## **Development Facilitation Team (DFT) – Review Comments**

**DRB Project No: PR-2023-008250 Date: 03/01/2023 Agenda Item: #2 Zone Atlas Page: B-15**

**REQUEST:** SITE PLAN ADMIN – DFT: Glass-Rite New Office/Warehouse: 5605 Venice Ave. NE

**Project Name:** Glass-Rite New Office/Warehouse: 5605 Venice Ave. NE

5605 Venice Ave NE

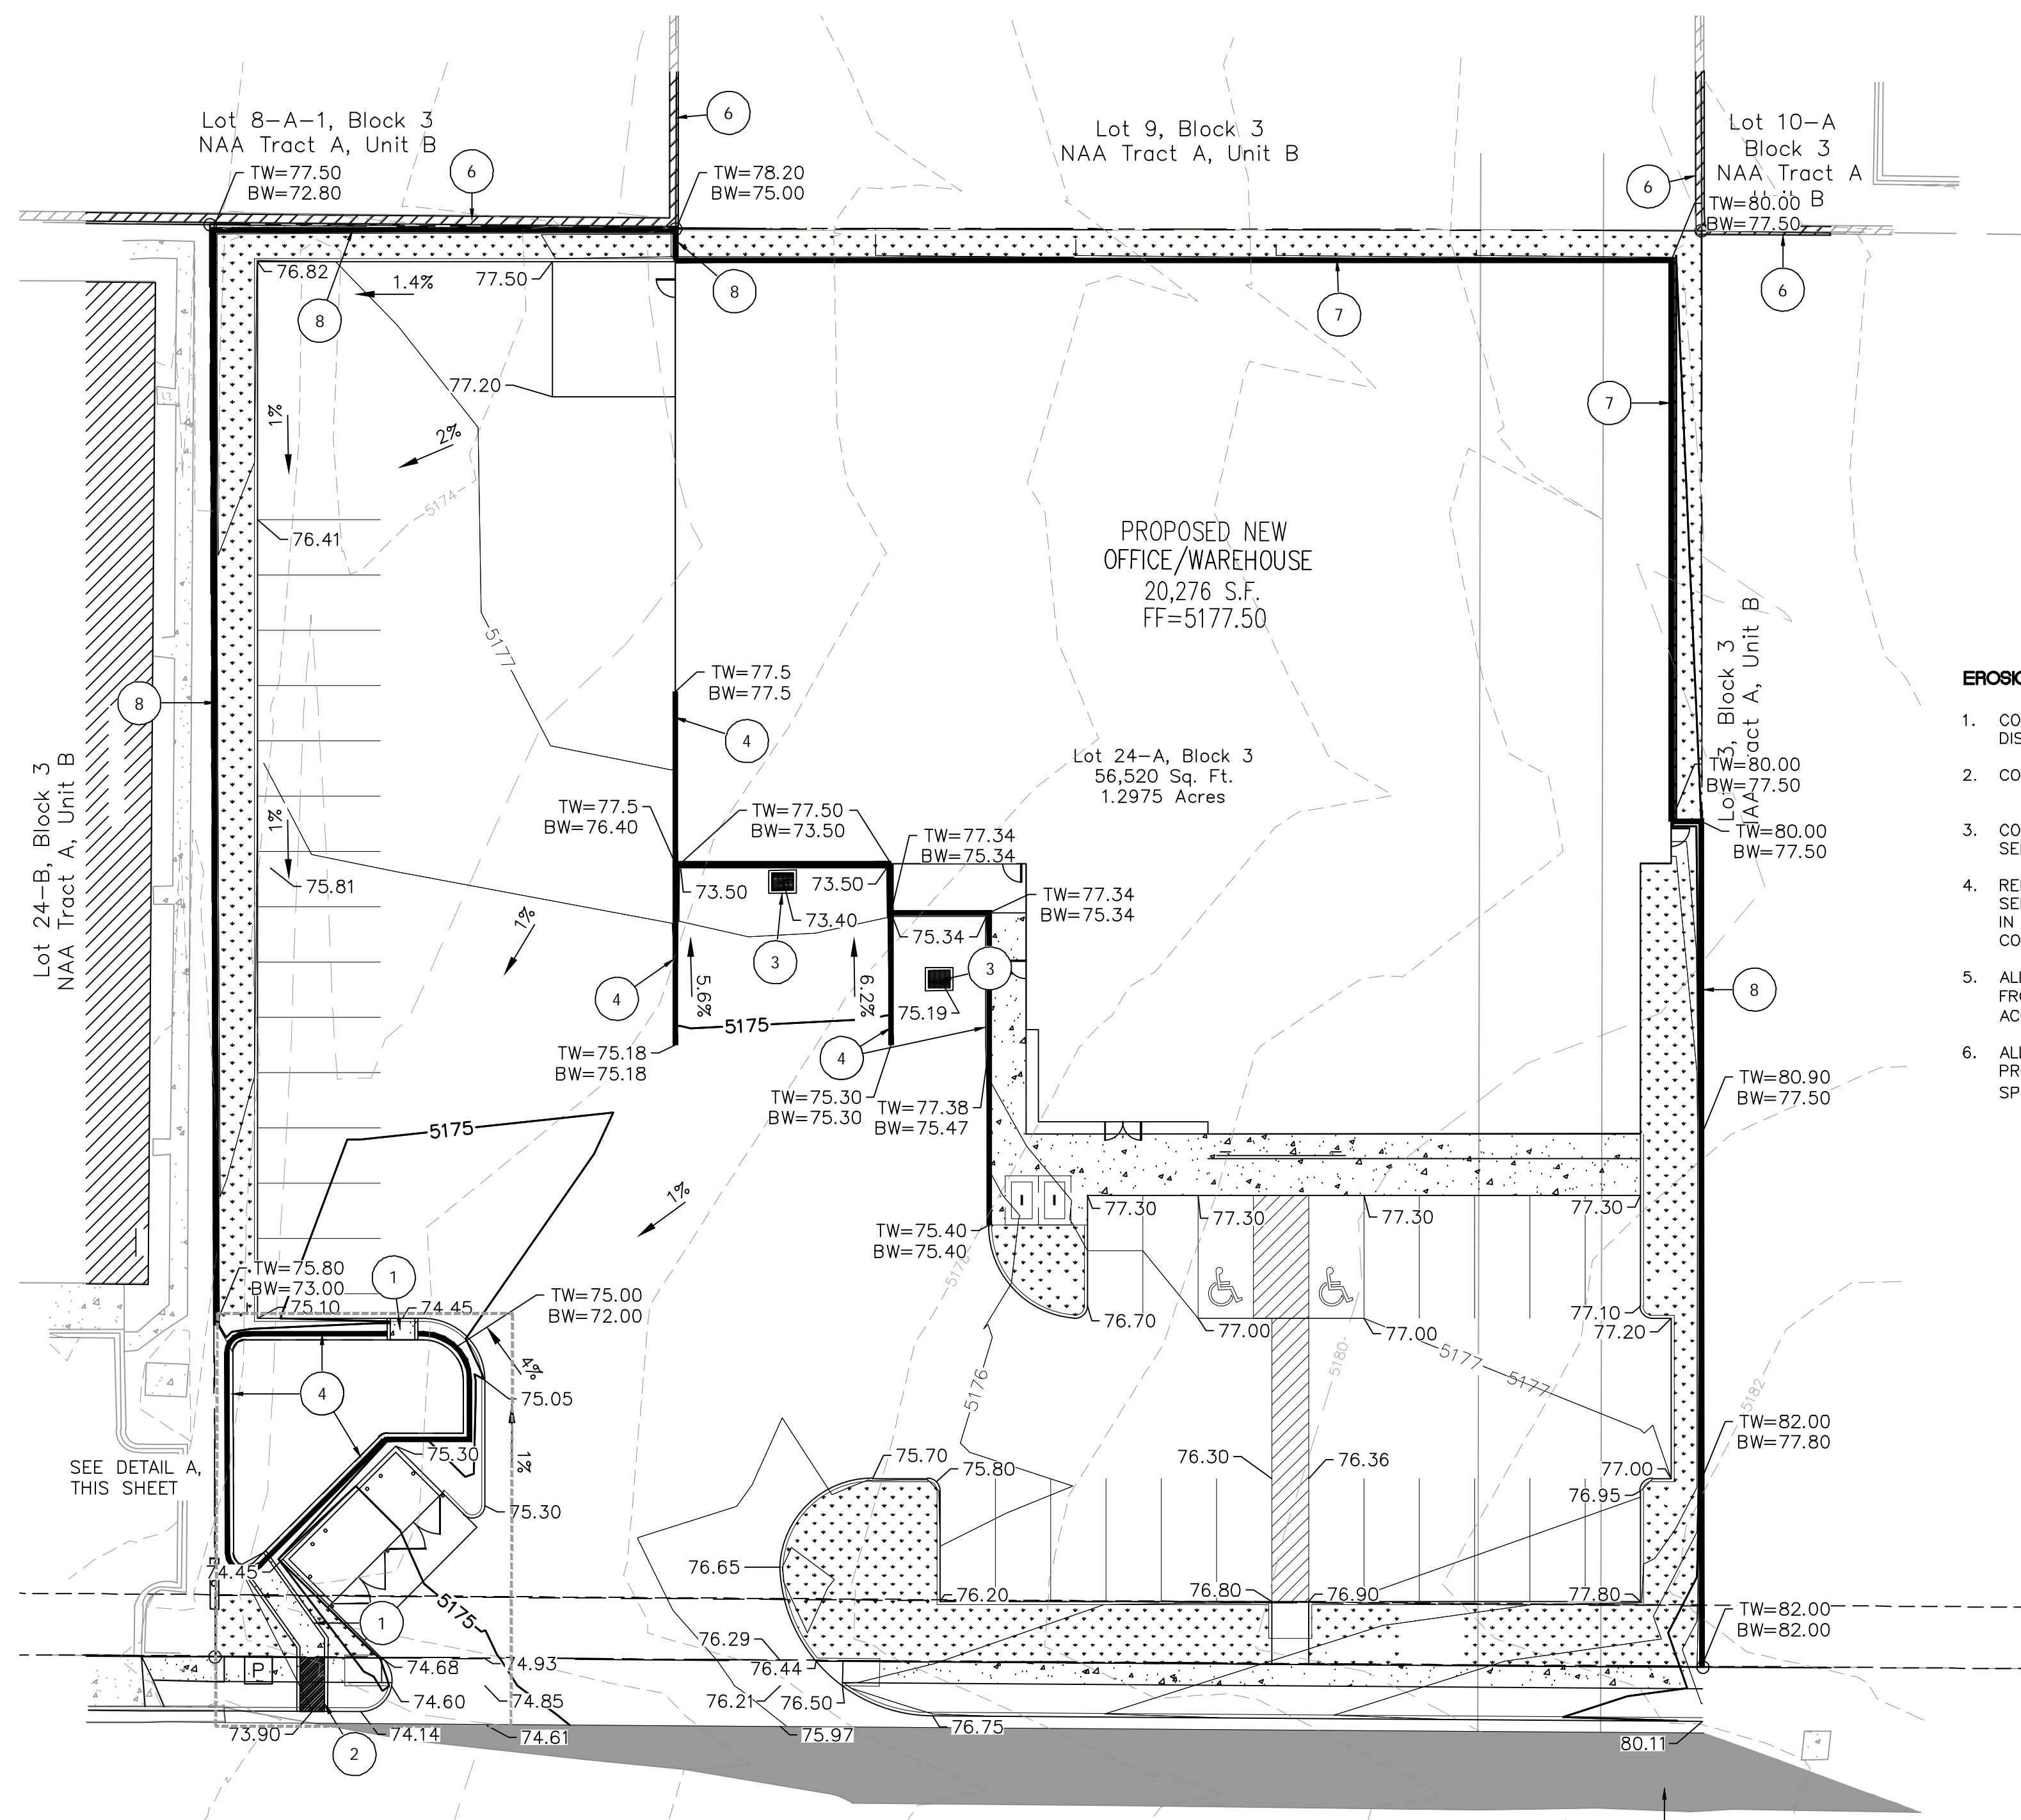
1. Availability Statement 220930 provides conditions for service.
2. Please provide a site utility plan showing all dimensions and water and sanitary sewer sizing.
  - a. Label public vs. private infrastructure
  - b. Call out dimensions
  - c. Include line spots
  - d. Meter sizing needed
  - e. SAS service.
